Application No: FP/134/25/HH

Site Address: Old Watch House Old Coastguards Felpham PO22 7BJ

Description of works: Demolition of the existing garage and replacement with new store and residential annex to the main house.

Felpham Parish Council OBJECT to this application on the following grounds:

Drawn By: PAL	Issued By: PAL	Date of First Issue: 12:02:25
Project No: 2024_448		Scale @ A1 / A3: 1:50 / 1:100
Drawing No: PL_200		Revision: 08

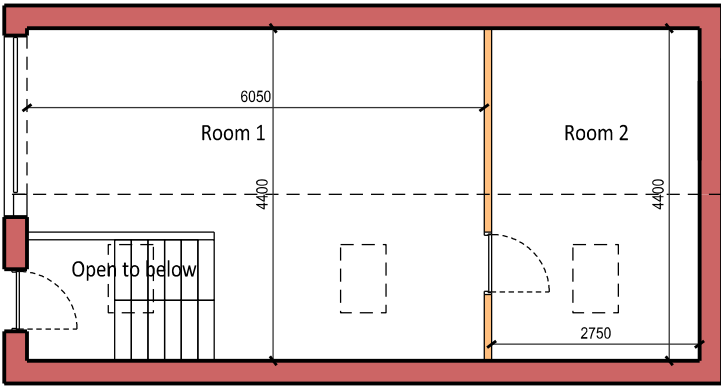
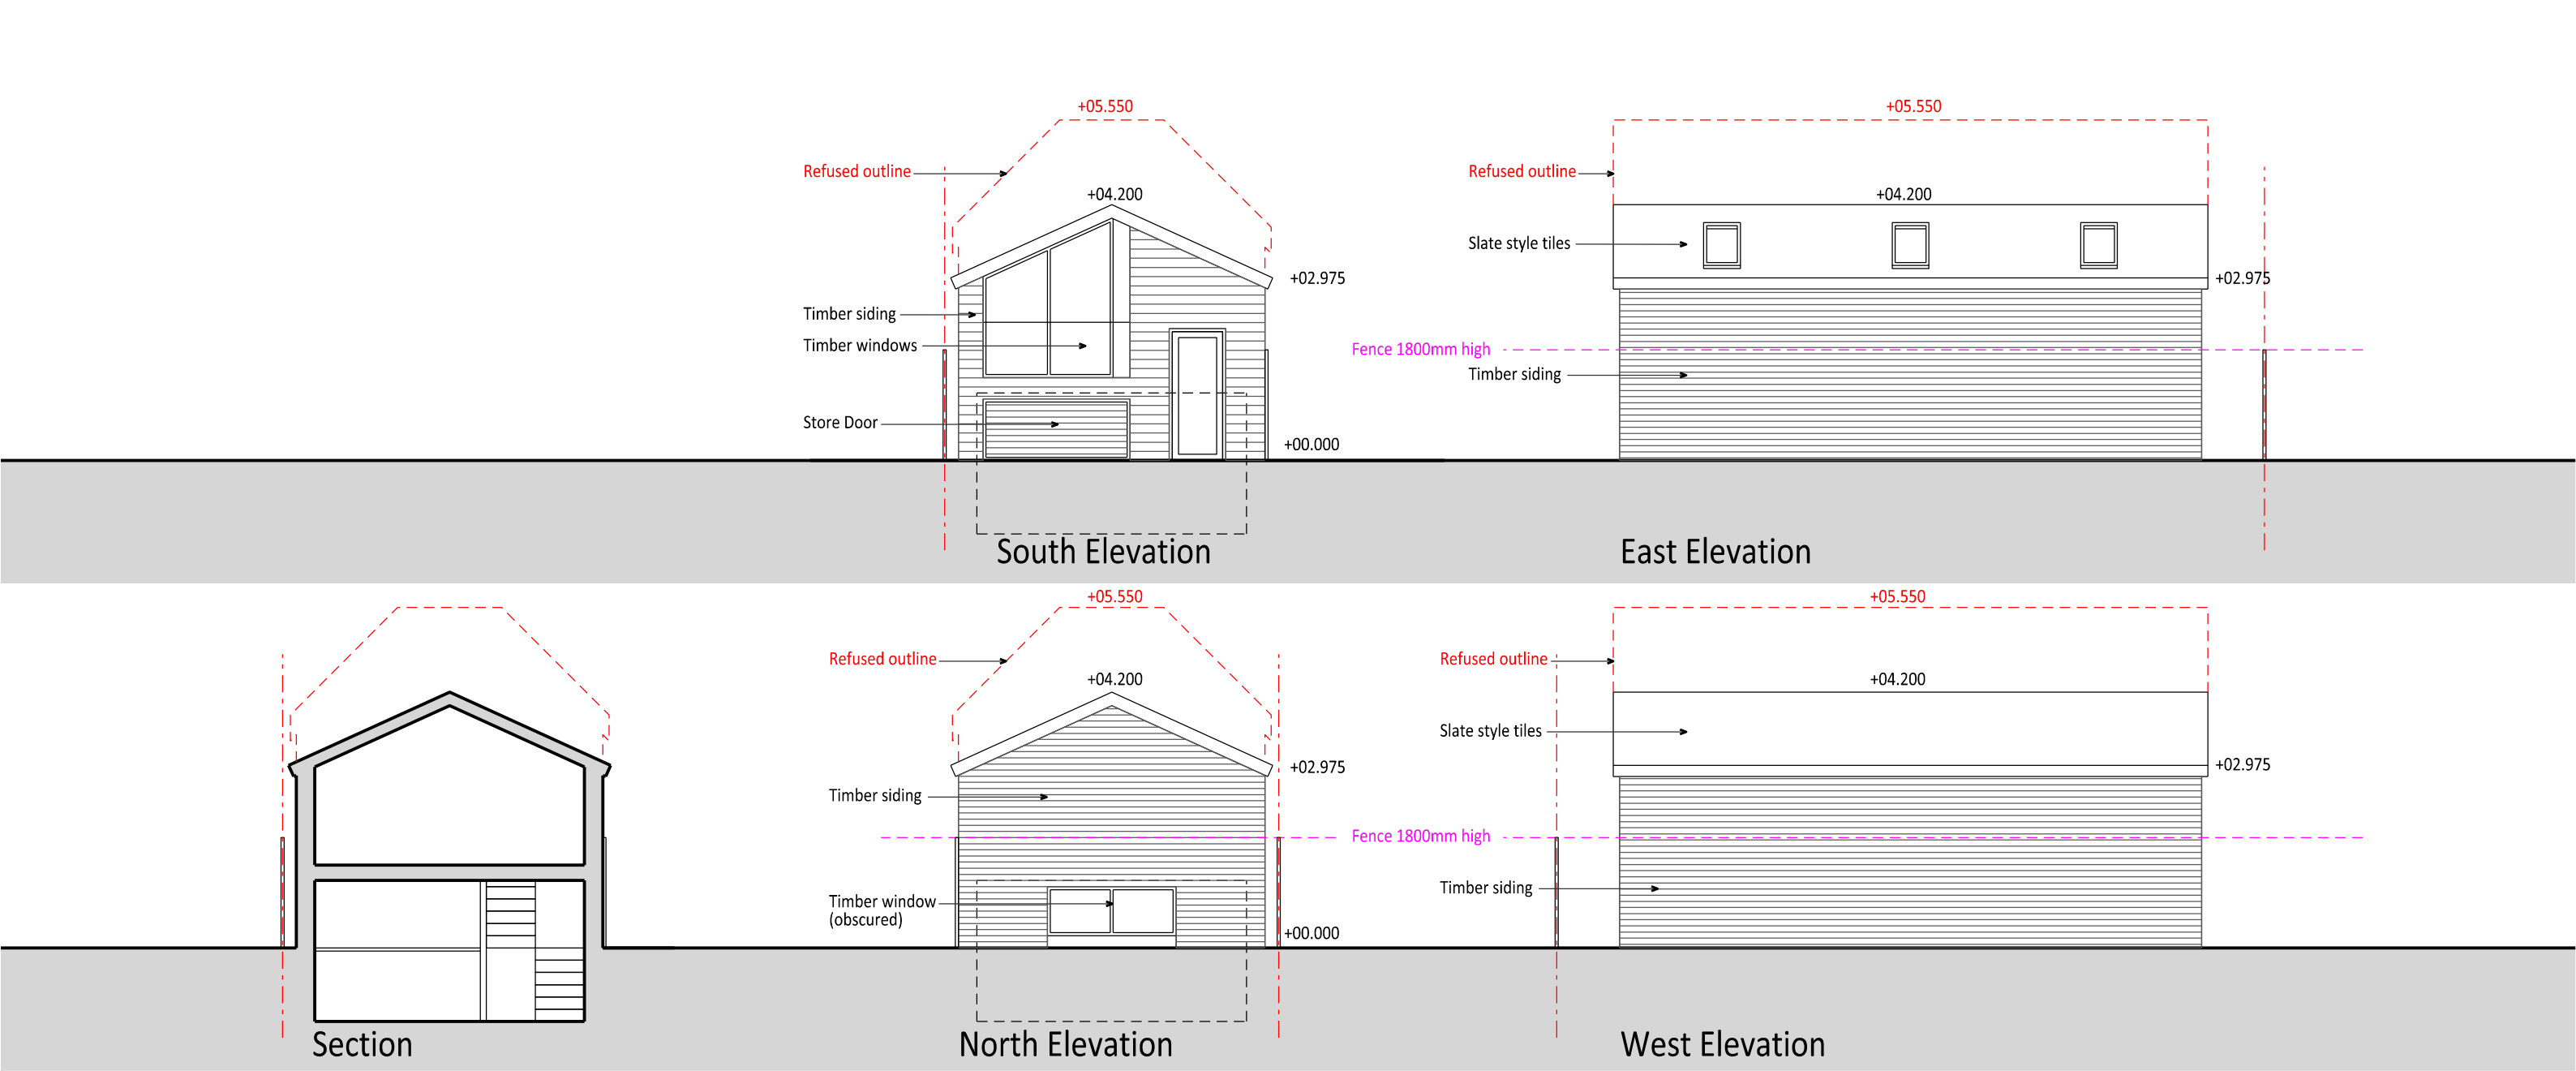
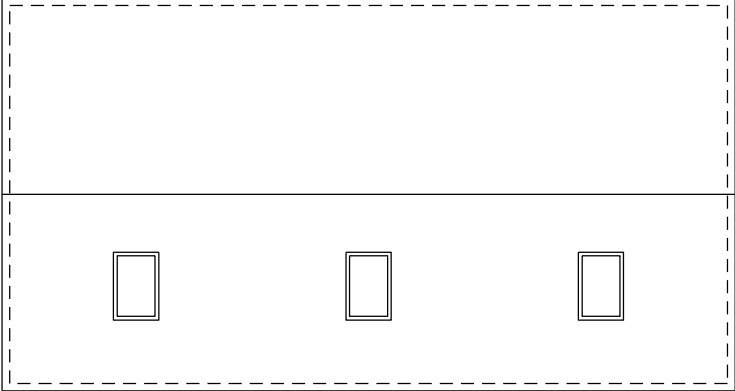
Does not meet technical housing standards - nationally described space standard. The minimum gross internal floor area for two storey two bed dwelling is 79 sqm.

Overshadowing of neighbouring property.

1 metre gap from boundary at first floor level not maintained.

Overdevelopment of site.
